PLANNING DECISION NOTICE – REFUSAL

S6/2003/136/FP

ERECTION OF A FIRST FLOOR SIDE EXTENSION

at: 131 THE RIDGEWAY, NORTHAW, POTTERS BAR

Job
PROPOSED FIRST FLOOR SIDE
EXTENSION
Site 131 The Ridgeway, Cuffley,
Scale 1:50 Date December 2002
Drawing Number 131B/1
JOHN PERRIN & CO.
Building Surveyors,
885 Green Lanes,
Winchmore Hill, London. N21 2QS

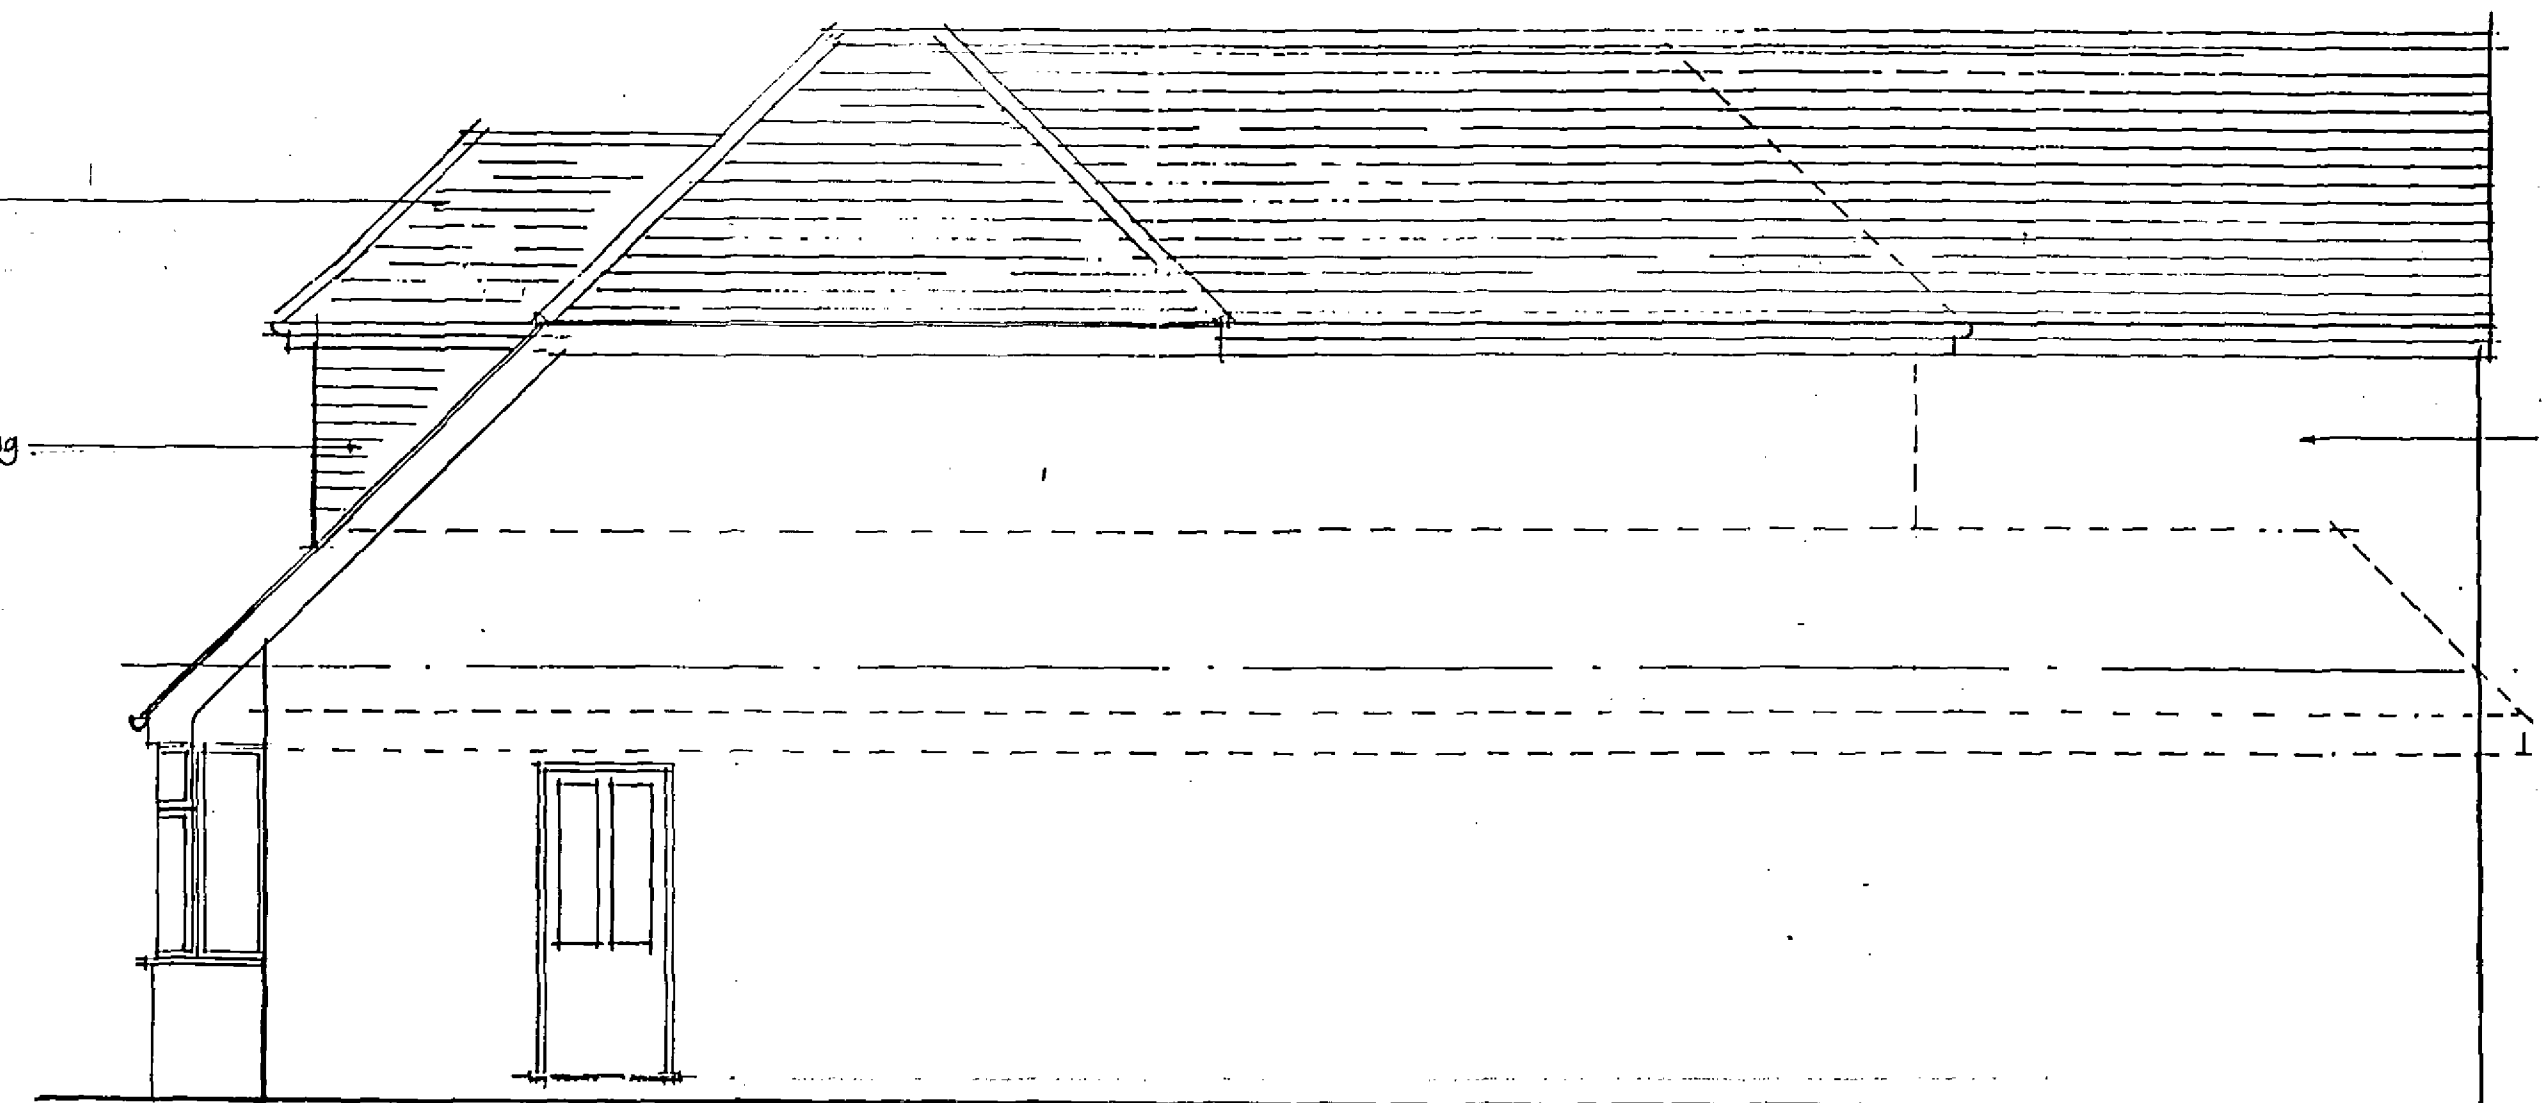
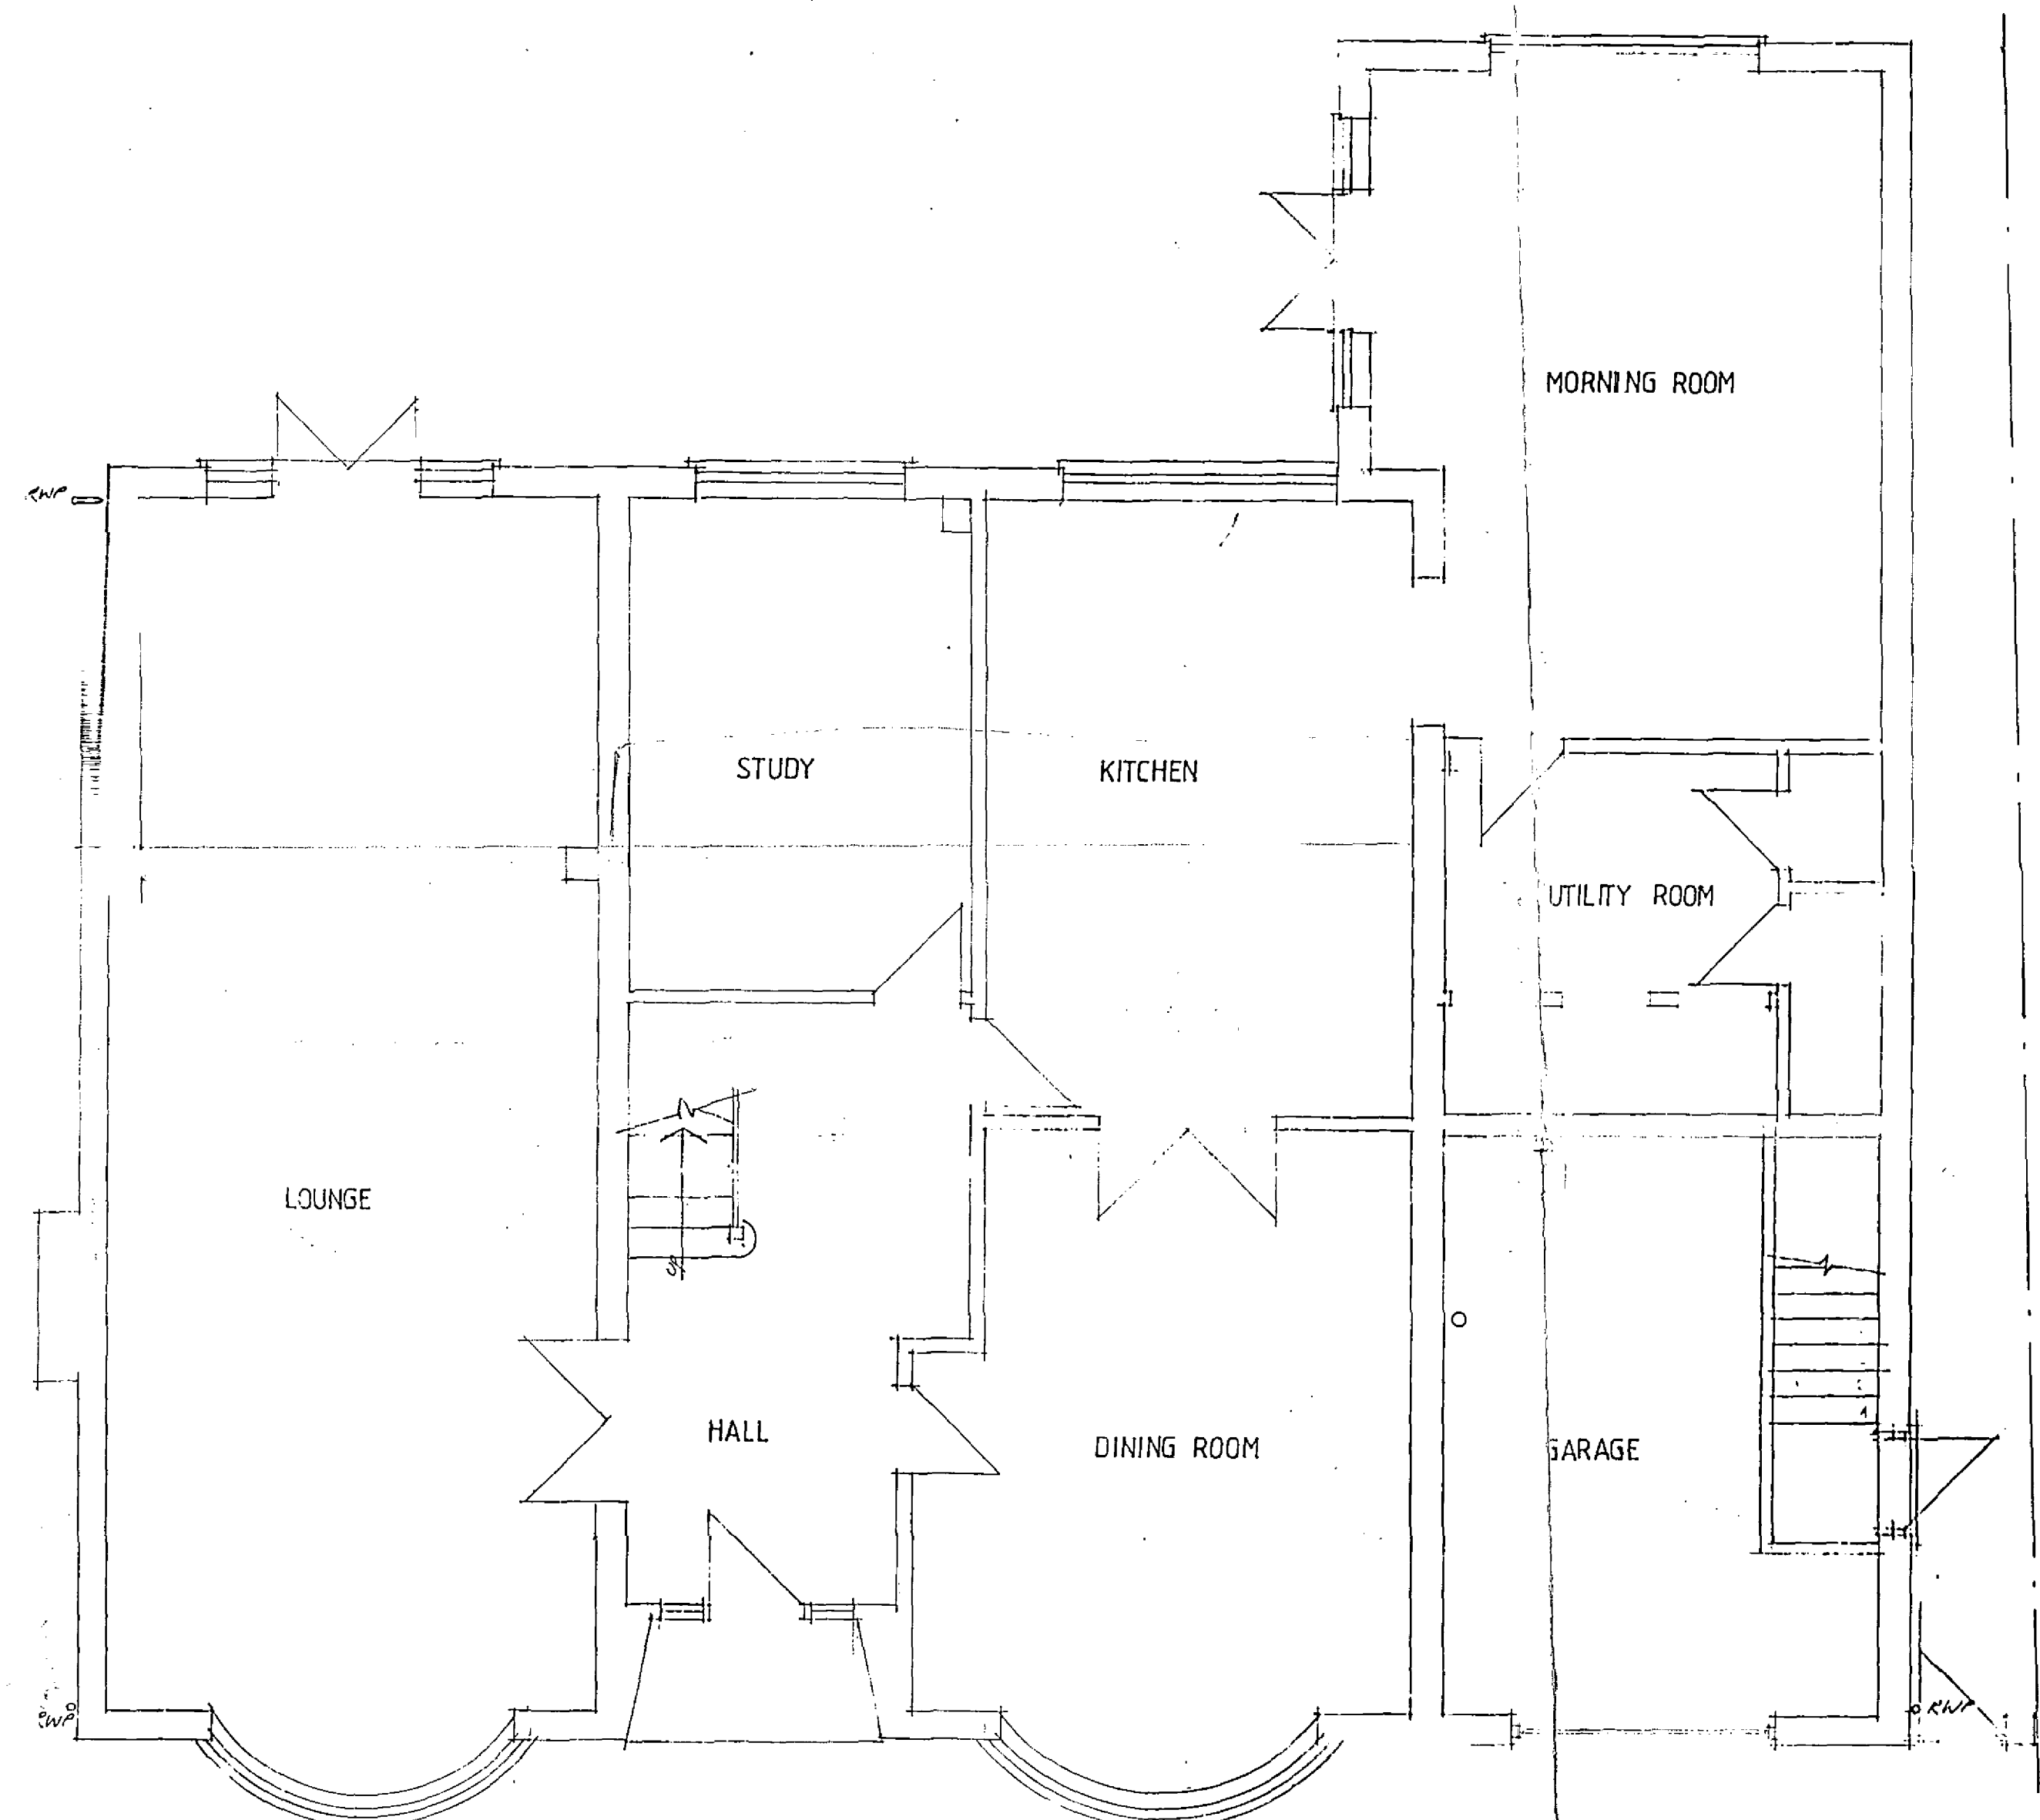
1. The application site is located within the Metropolitan Green Belt where only certain forms of development, including limited extensions to residential dwelling houses that, in accordance with Policy 5 of the Hertfordshire County Structure Plan Review 1991 - 2011 and Policy GB5 of the Welwyn Hatfield District Plan Alterations No 1, 1998, do not have an adverse or disproportionate impact upon the character, appearance and visual amenity of the surrounding countryside, may be permissible. Together with previous extensions to the dwelling, the proposal represents a cumulative increase in the floorspace of the dwelling of 201.4%. This increase in floorspace, over and above that of the original dwelling would have a disproportionate impact upon the character and appearance of the surrounding countryside and would have an adverse impact upon the openness of the Green Belt. As such, the proposed development is contrary to Policy 5 of the Hertfordshire County Structure Plan 1991 - 2011 and Policy GB5 of the Welwyn Hatfield District Plan Alterations No. 1, 1998.

2. By virtue of the proximity of the extension to the flank boundary of the curtilage with No. 133 The Ridgeway, the extension would appear unduly dominant and visually intrusive when viewed from that dwelling. The resultant dwelling would appear cramped within its plot to the detriment of the street scene. Furthermore, less than one metre would remain between the flank elevation of the extension and the side boundary of the curtilage. The proposed development is therefore contrary to Res Criteria 22 and 23 of Appendix A of the Welwyn Hatfield District Plan Alterations No. 1, 1998.
